**Re: EXHIBITION OF STATE SIGNIFICANT DEVELOPMENT APPLICATION SSD-8586218**

<b>PROPOSAL:</b>	<b>TEMPERATURE CONTROLLED WAREHOUSE FACILITY</b>
<b>ADDRESS:</b>	<b>LOT 4, BRINGELLY ROAD BUSINESS HUB, LEPPINGTON (LOT 11 DP 29104)</b>

LANDSCAPE CONCEPT DOCUMENTATION

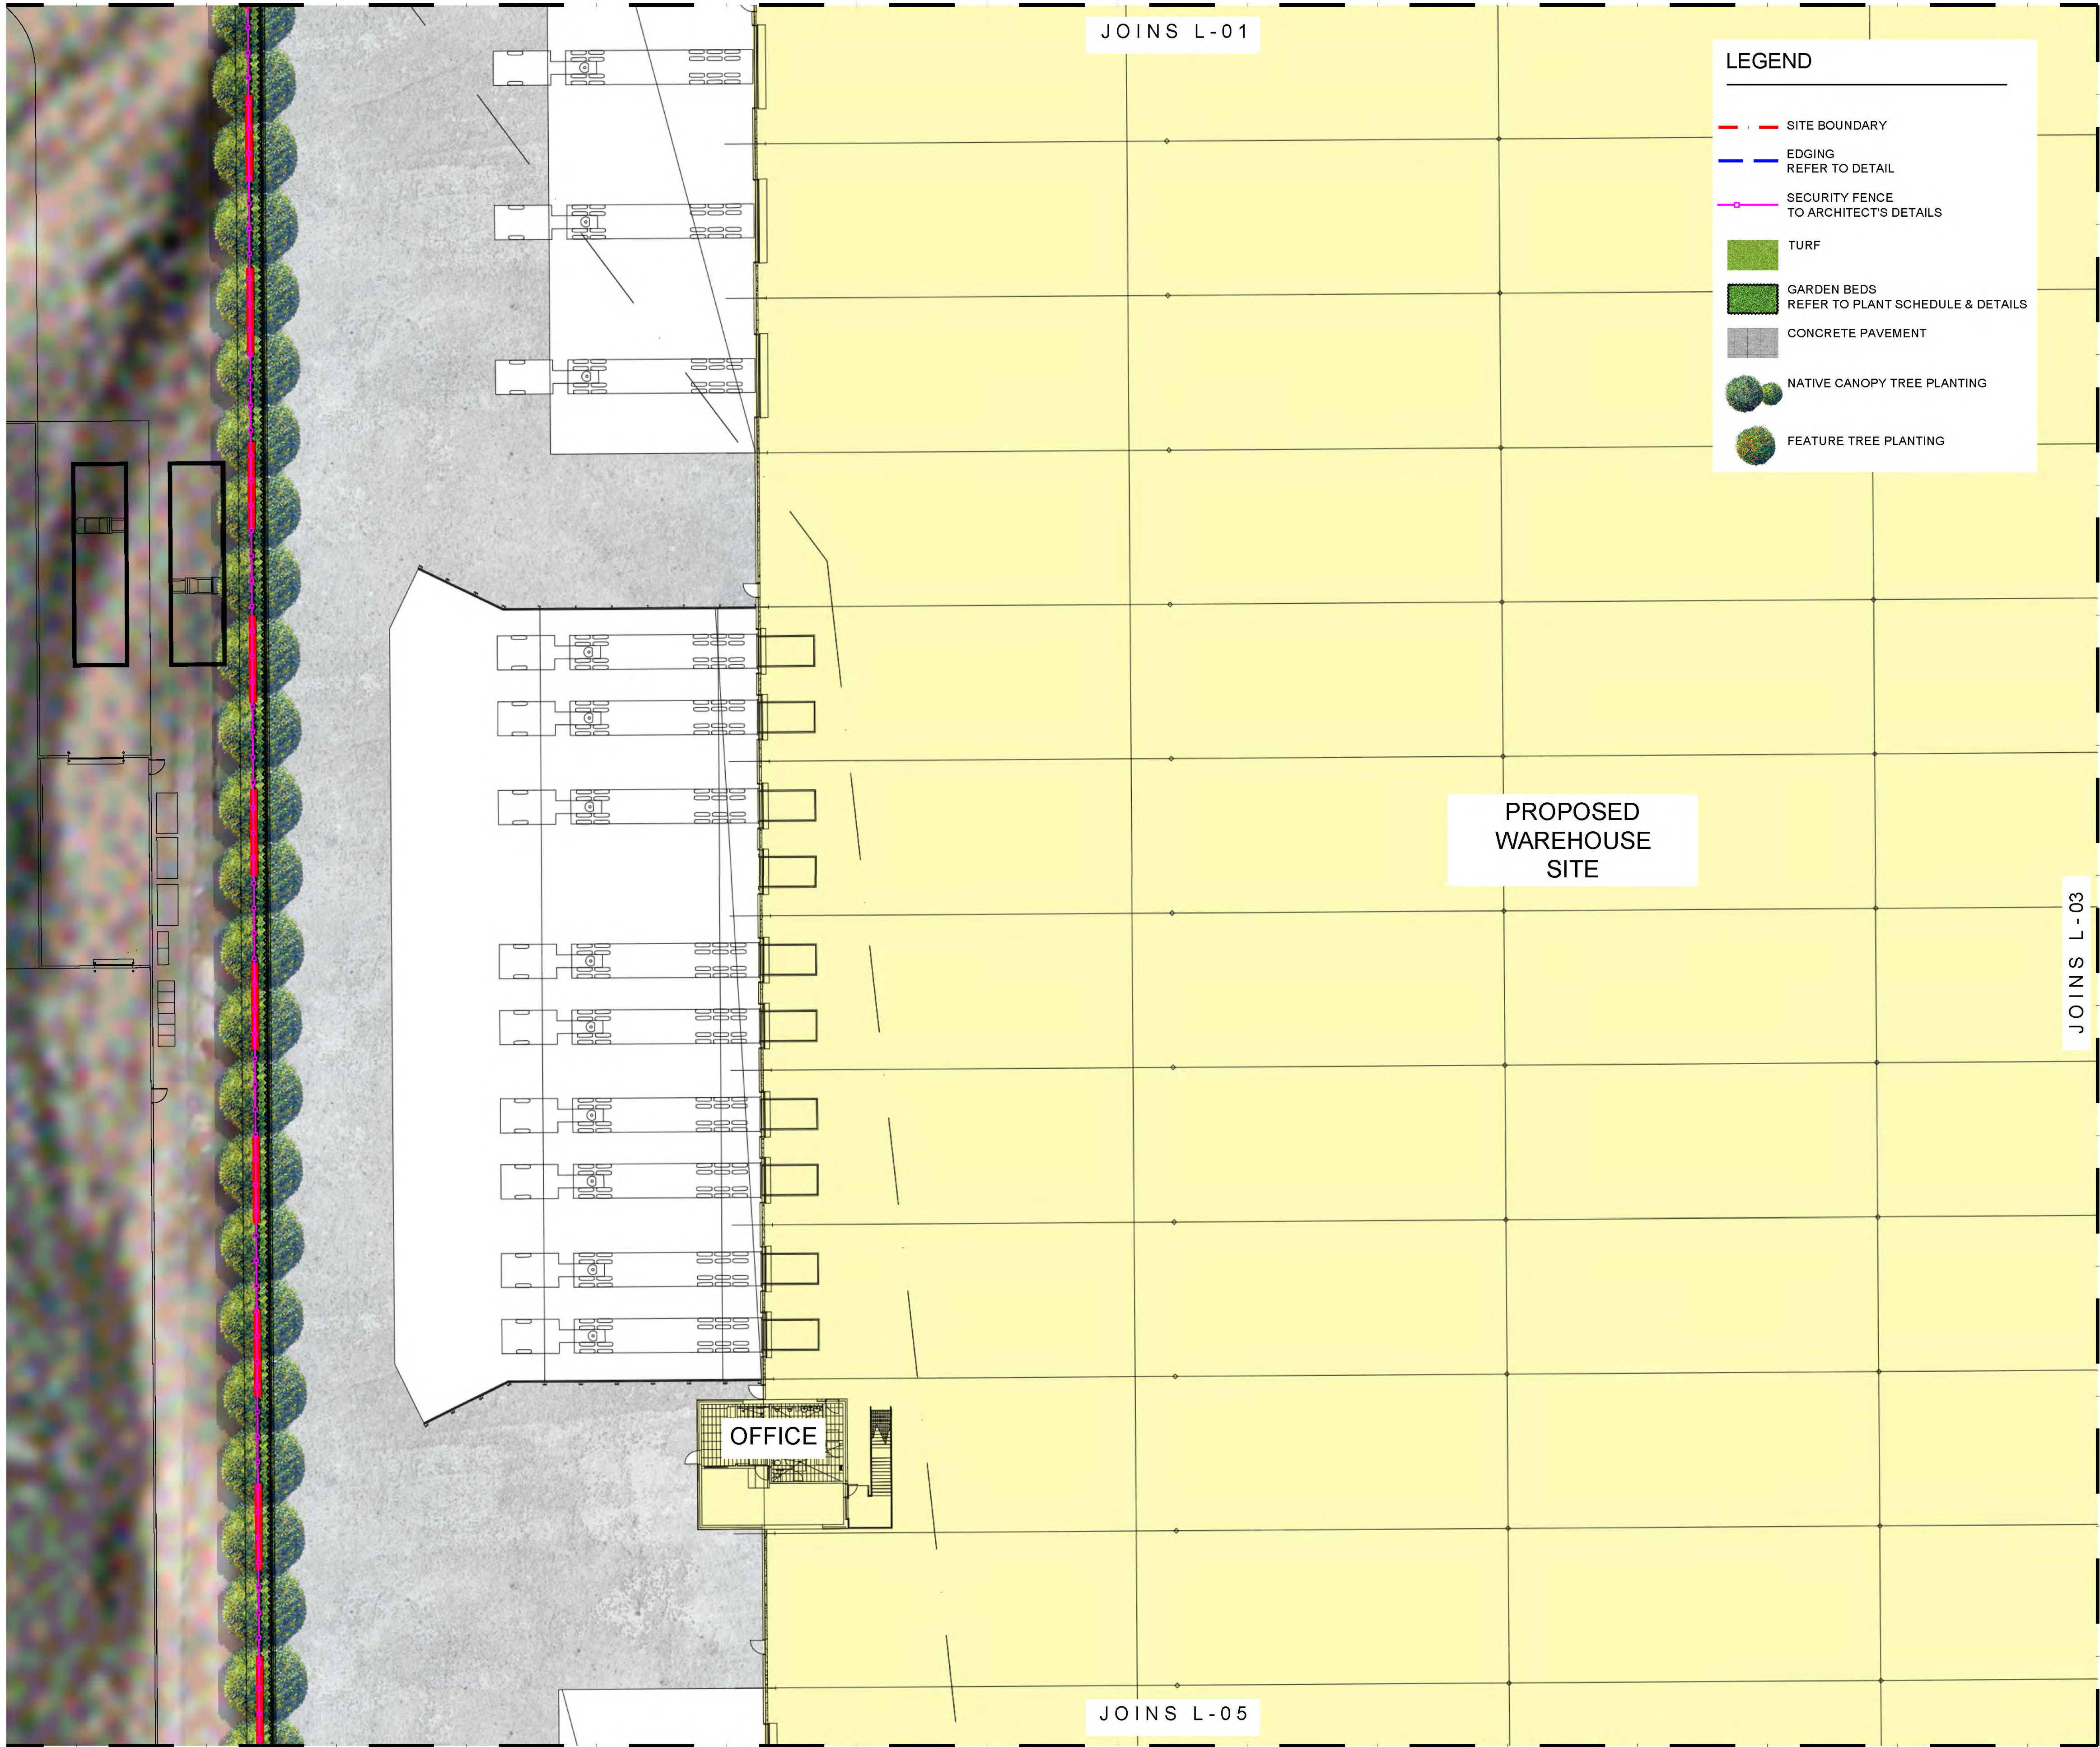
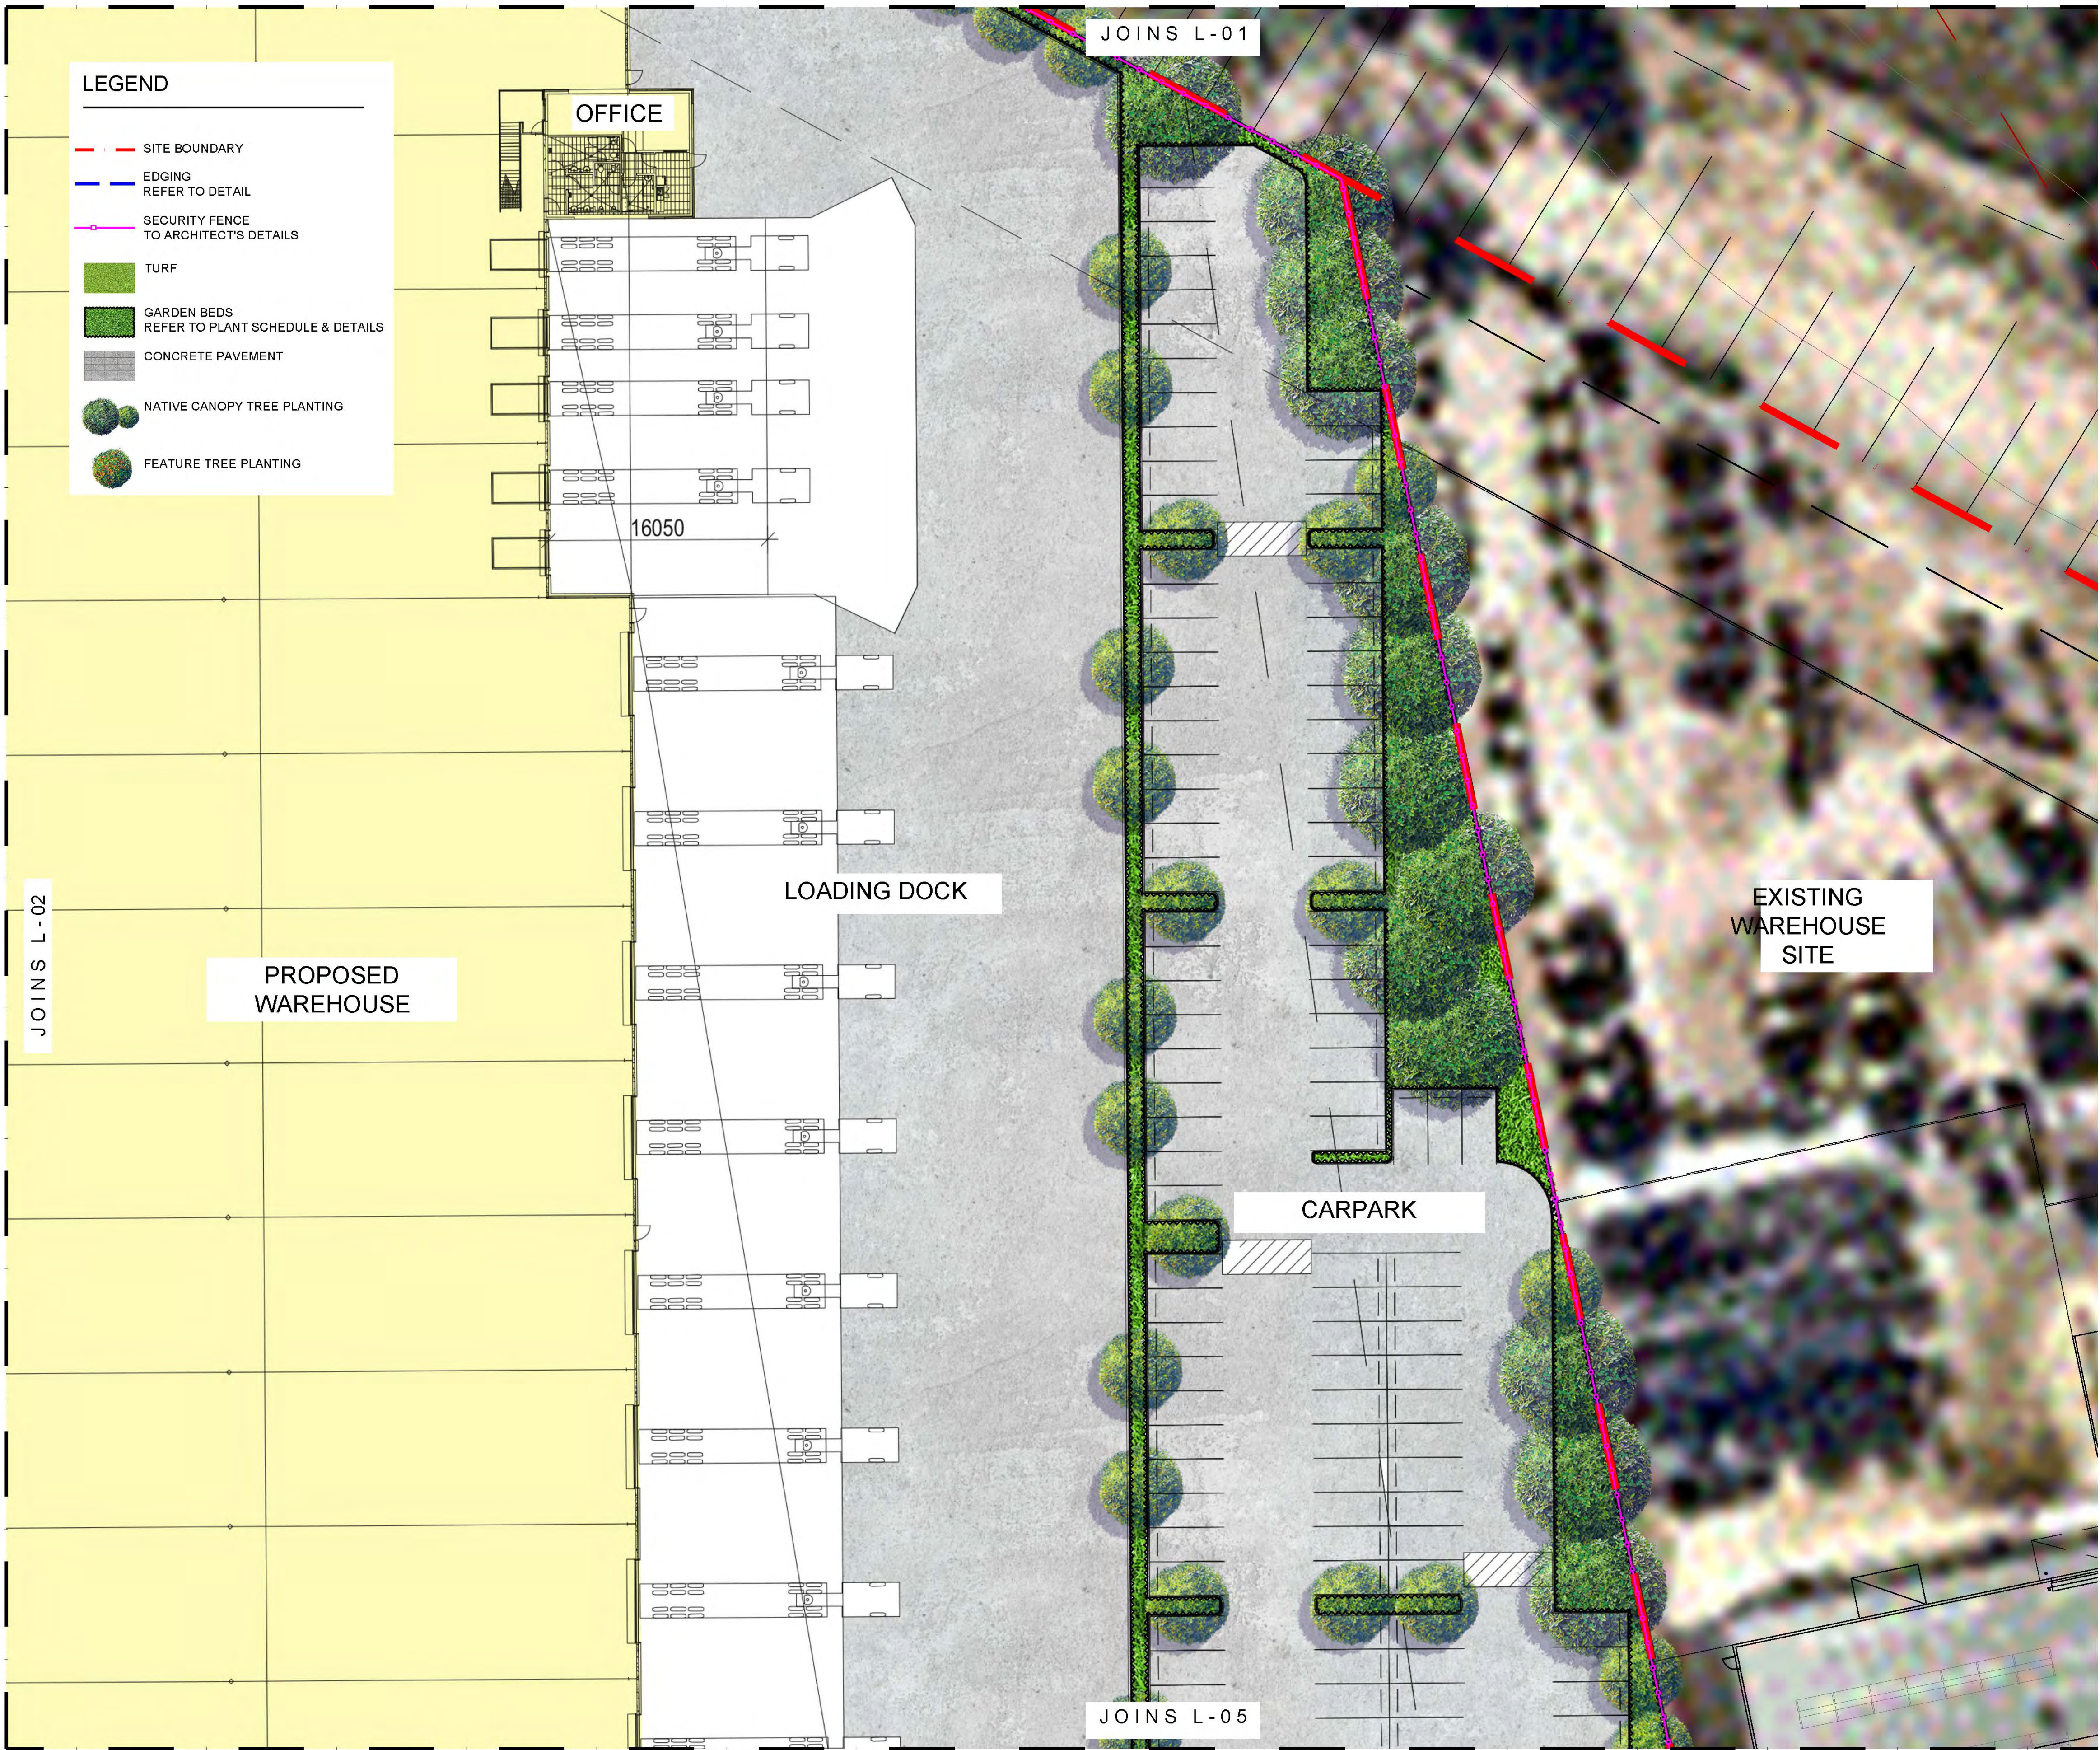
2. Council commends the incorporation of landscaping at the site. Notwithstanding this, it is important to maximise the amount of landscaping to ensure an optimal sustainability outcome. Having regard to the submitted traffic report, it is noted that there are hardstand areas adjacent to the perimeter planting that do not appear to be required for vehicle maneuvering and/or parking. In this case, there appears to be scope for an increase in landscaped areas around the perimeter of the site.
3. Council has reviewed the submitted landscape plan prepared by Habit8. It is noted that this plan indicates planting on the site yet does not denote the plant species. Furthermore, it is noted that the plant schedule does not provide details of the height and the canopy spread of each plant species. The landscape plan should be amended to rectify these matters.

Notwithstanding this, having regard to the submitted visual assessment, it is noted that the trees used on the site, especially those in the car park area and along the Stuart Street frontage do not appear to provide large canopy cover. It is recommended that the applicant provide for species with a larger canopy to provide more shaded areas and adequate screening.
